4th June 2021
Our Ref: D1922
ADC Ref: AL/27/21/PL

RE: AL/27/21/PL - FORMER GRAIN STORES, SACK LANE, LIDSEY

Thank you for passing on the comments from ADC with regard to the Flood Risk Assessment and Drainage Strategy submitted for the above planning application. Please find my response below.

Drawing Status	PLANNING		
Client	Melanie Jenkins		
Project	Impermeable Areas		
Drawing Title	Lidsey Lodge Farm Sack Lane, Lidsey PO22 9PE		
Scale	1:750	Date	Jun 2021
Drawn By	DJL	Checked By	LDF
Drawing No.	D1922-102		Rev. A

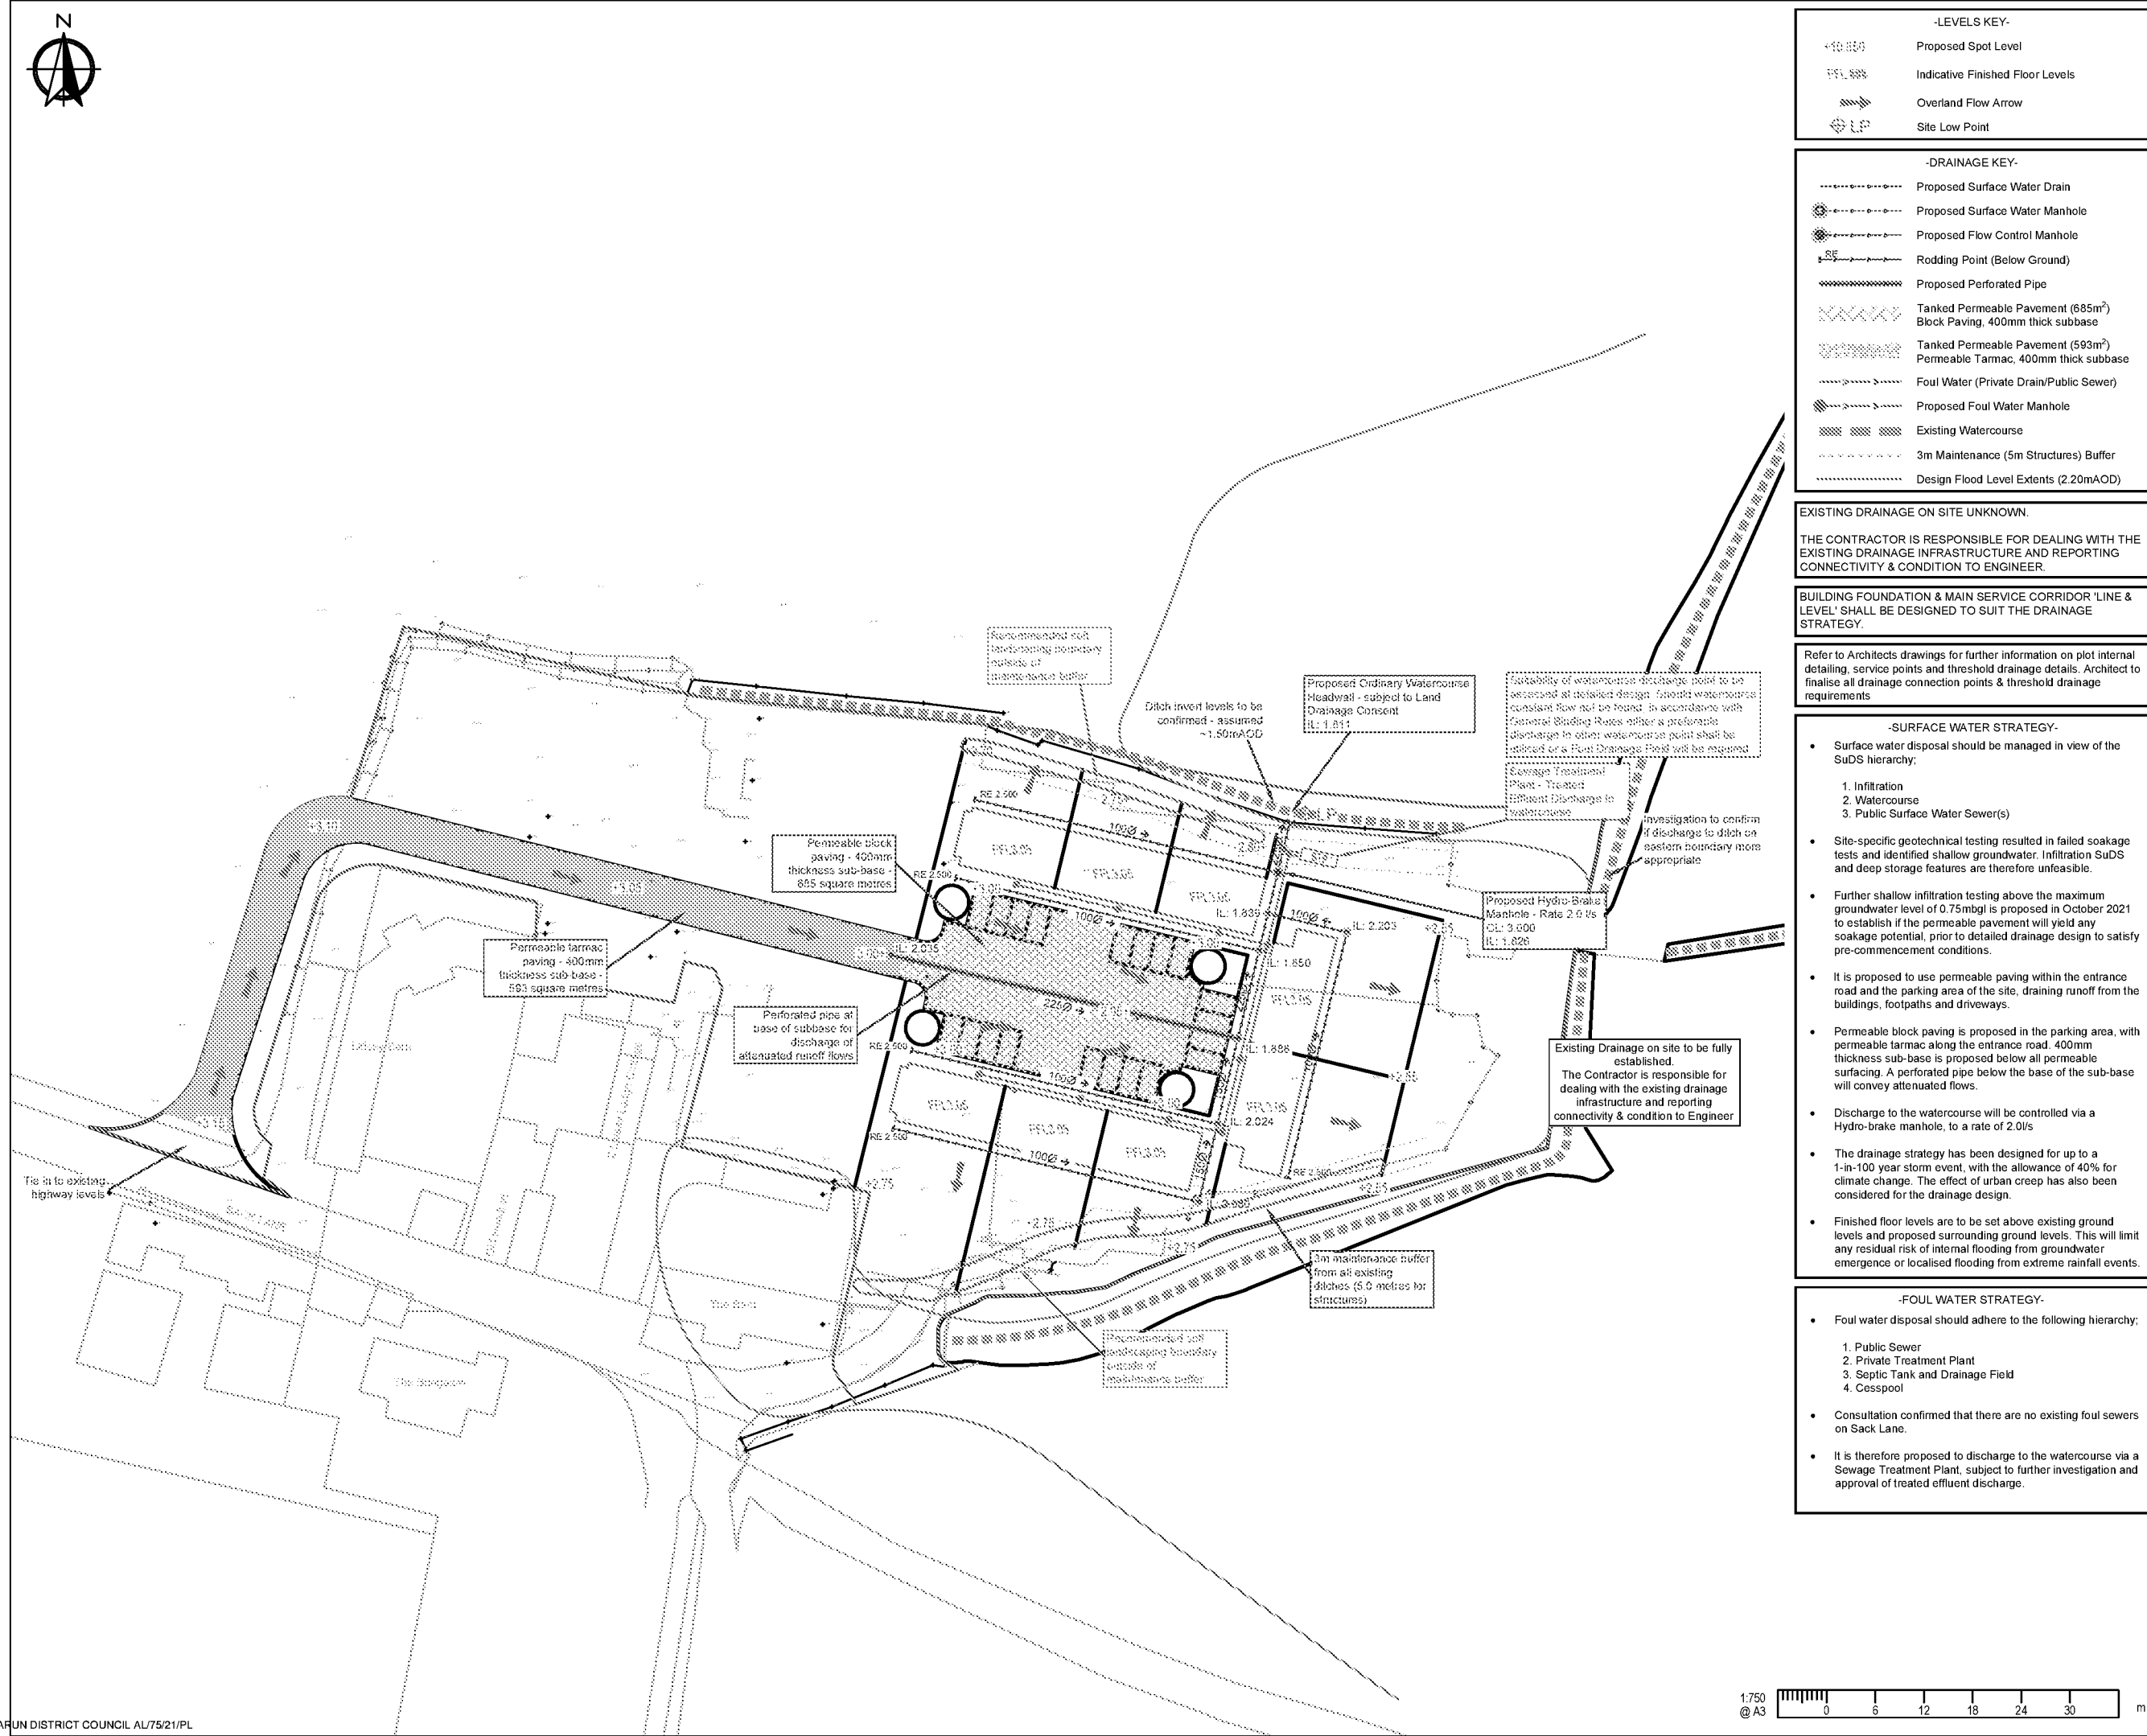
The applicants engineers are aware of the required easements to the watercourse as these are cited within the FRA. Please ensure that not only buildings, but also boundary fences are not sited within 3m of the watercourses. Please provide a plan showing the buffers and the flood zones if a future application is made.'

We are also agreeable that the maintenance buffer must be accounted for and have proposed a soft boundary feature in our revised Drawing D122-200 Rev A to allow for this. This will be addressed further at detailed design.
